Application Ref.: F/4/20/OUT

Applicant: Redrow Homes Southern Counties and Wates Developments Ltd

Proposal: Outline planning application (with all matters reserved except for access) for the development of up to 1,500 dwellings (Use Class C3), 60-bed care home (Use Class C2), up to 9,000 sqm. of employment floorspace (Use Classes B1), local centre of up to 2,350 sqm including up to 900 sqm retail/ commercial (Use Classes A1-A5) and 1,450 sqm community/ leisure floorspace (Use Classes D1-D2), land for a two-form entry primary school (Use Class D1), public open space, allotments, new sports pitches and associated facilities, drainage, parking and associated access, infrastructure, landscape, ancillary and site preparation works, including demolition of existing buildings and part removal of existing runway hardstanding.

Location: Land at Ford Airfield Ford

**FIGURE 2:**  
**CUMULATIVE SCHEMES PLAN**

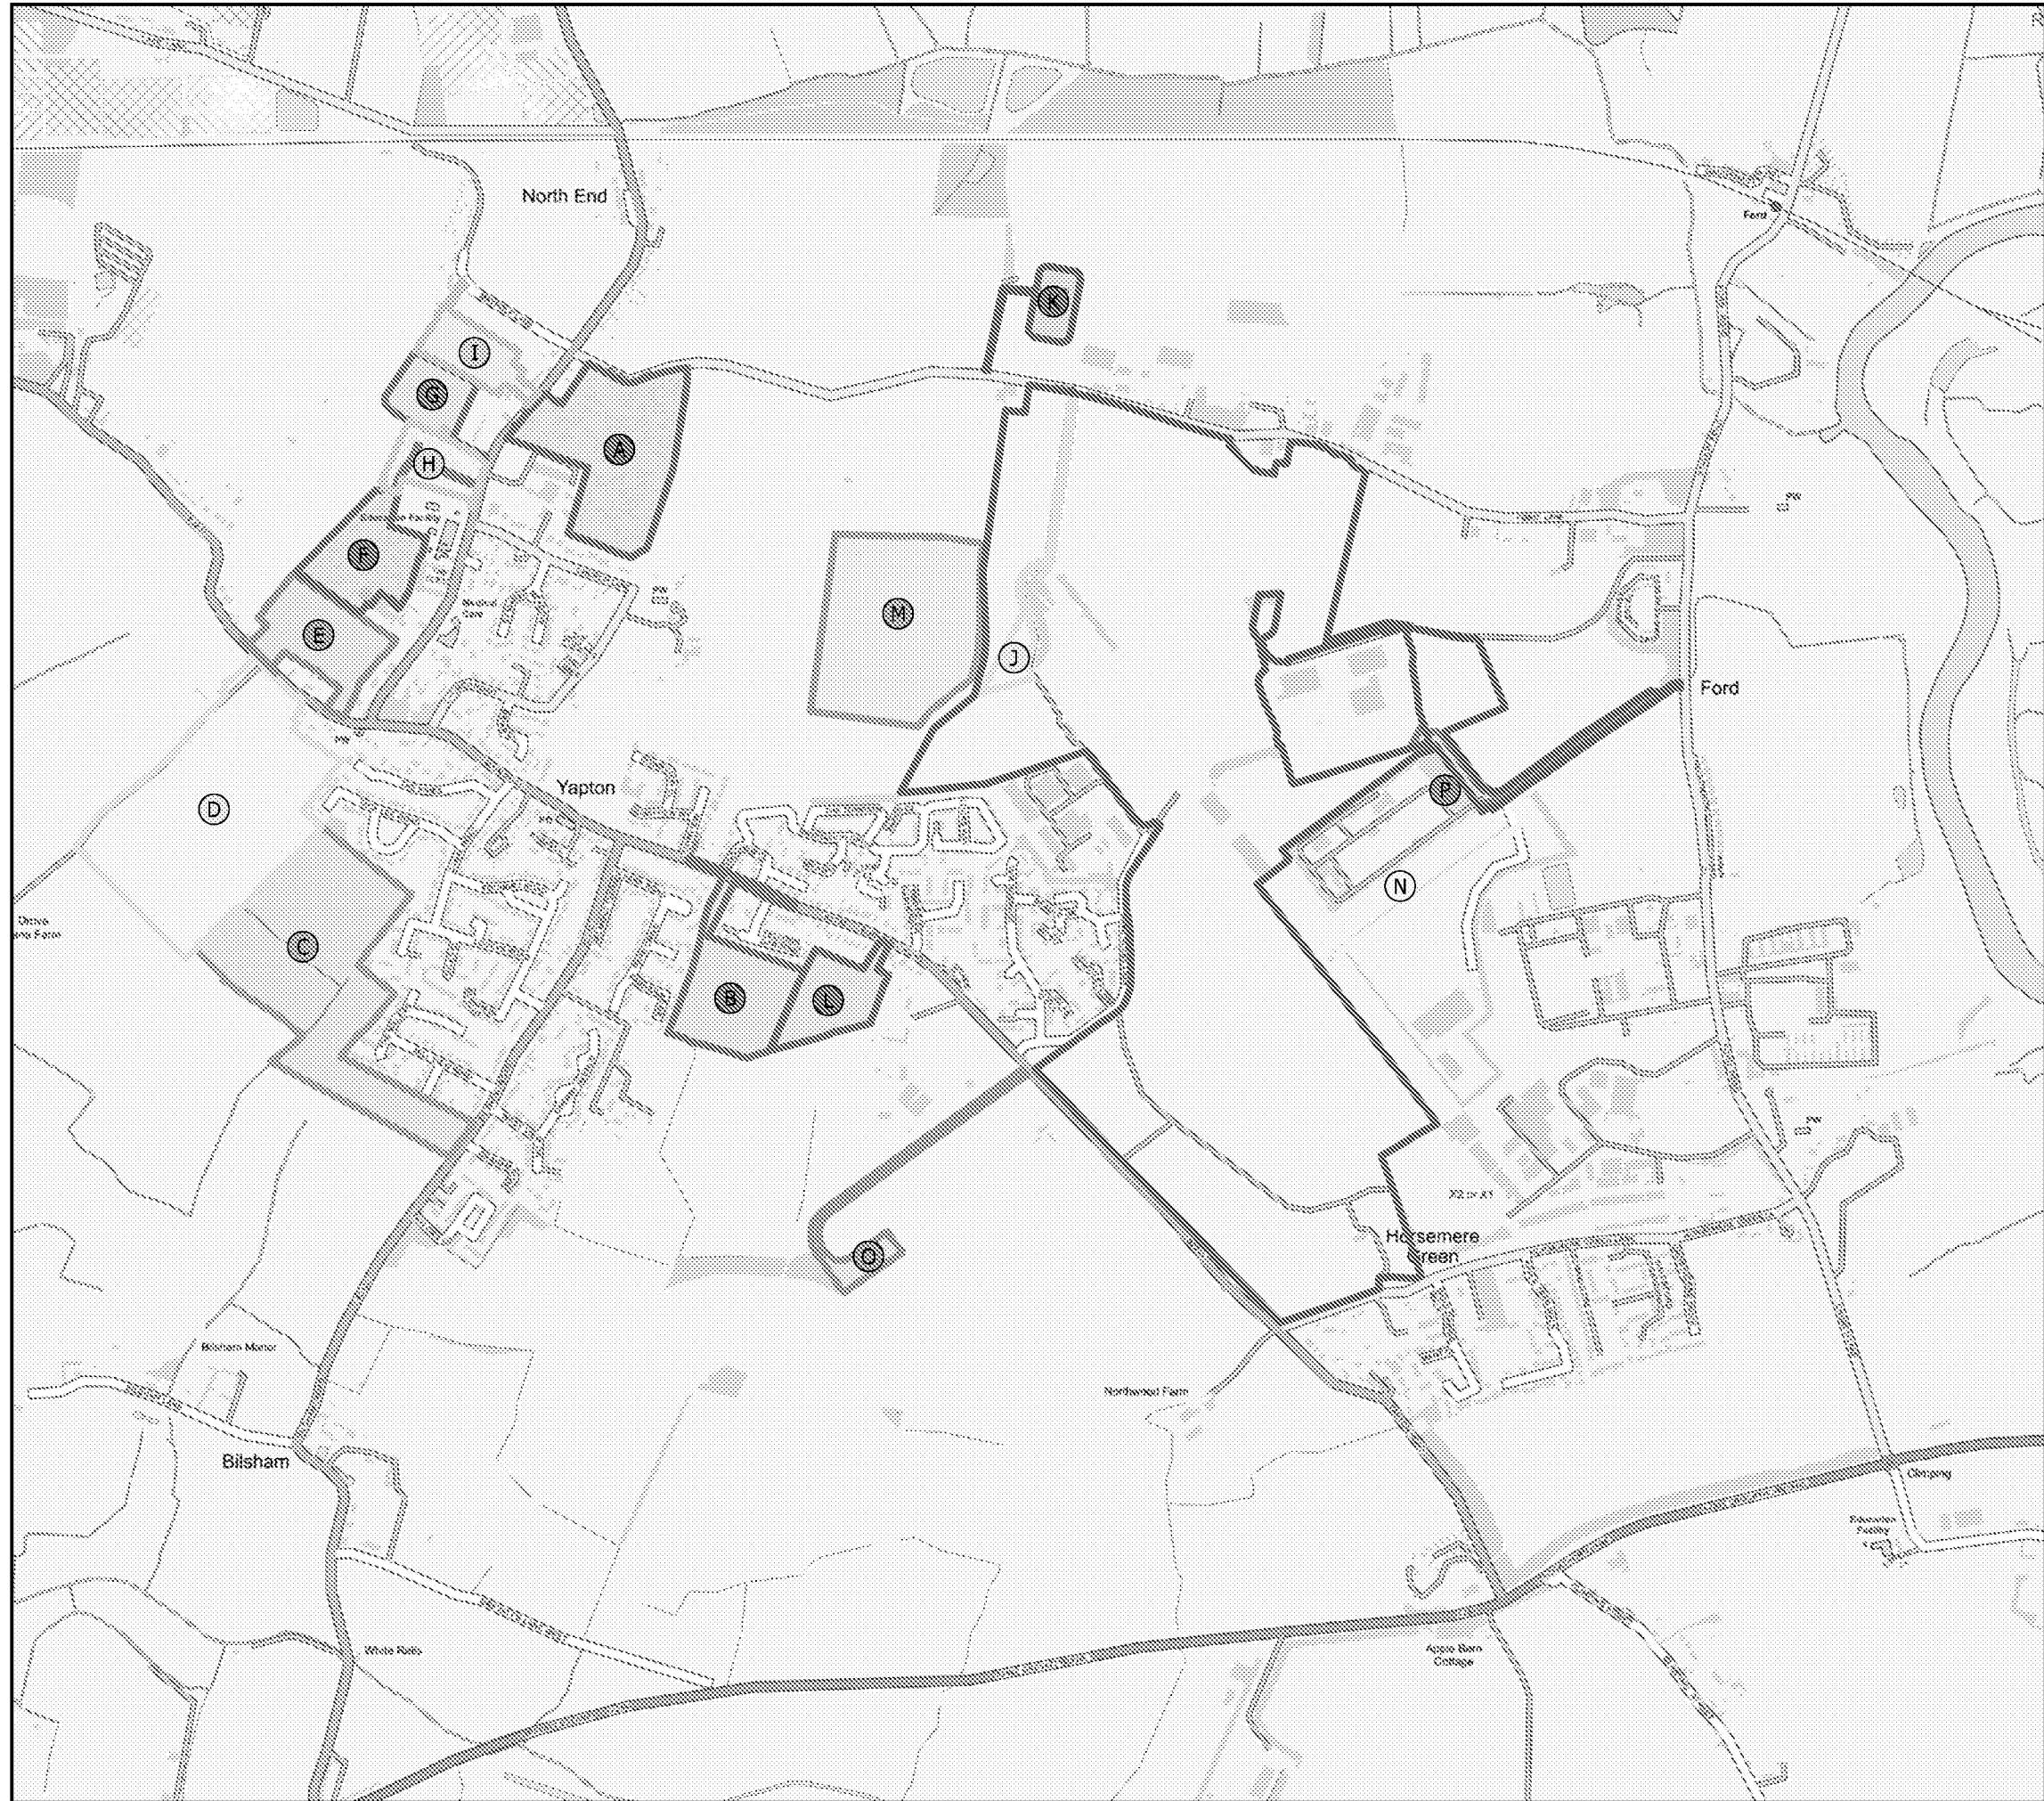
From our review of the Regulation 25 submission, it is considered that the Cumulative Impact Assessment is incomplete as it fails to take into account the following:

- 1) Planning Application WSCC/036/20 submitted by Ford Energy from Waste Limited for the development of an Energy Recovery Facility and a Waste Sorting and Transfer Facility at Ford Circular Technology Park.
- 2) Potential commercial and employment land located off Ford Road as identified within the most recent version of Ford Masterplan.

Figure 4: Typical illustrative plan showing noise mitigation principles, subject to detailed noise assessment and layout planning at reserved matters stage. Not for approval of detailed block layout or type/mix of housing.

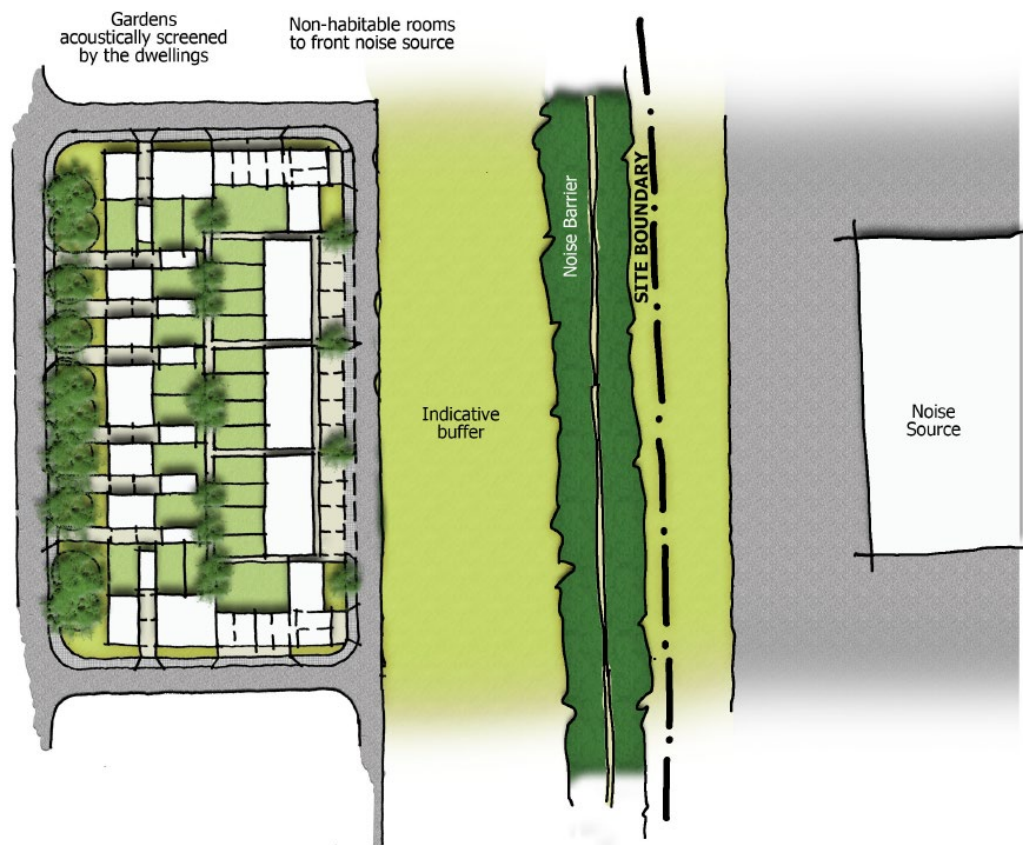
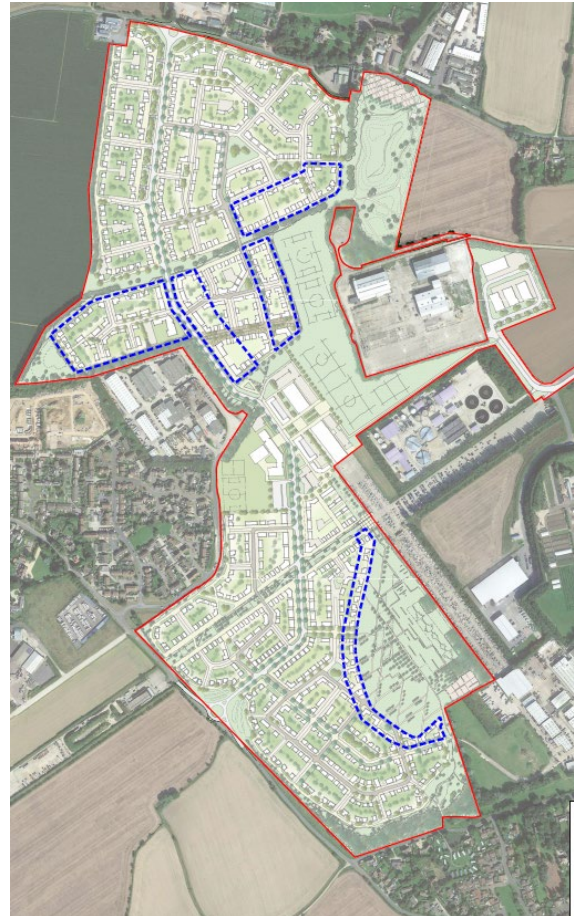
Firstly, the additional noise assessment fails to assess planning application WSCC/036/20 submitted by Ford Energy from Waste Limited and secondly, we have major doubts regarding the suitability and deliverability of the noise mitigation measures relied on by the applicants.

We would strongly encourage Arun District Council to seek clarification from the applicant on how the residential dwellings can be configured to ensure that no habitable rooms face any of the industrial uses within the vicinity of the application site.
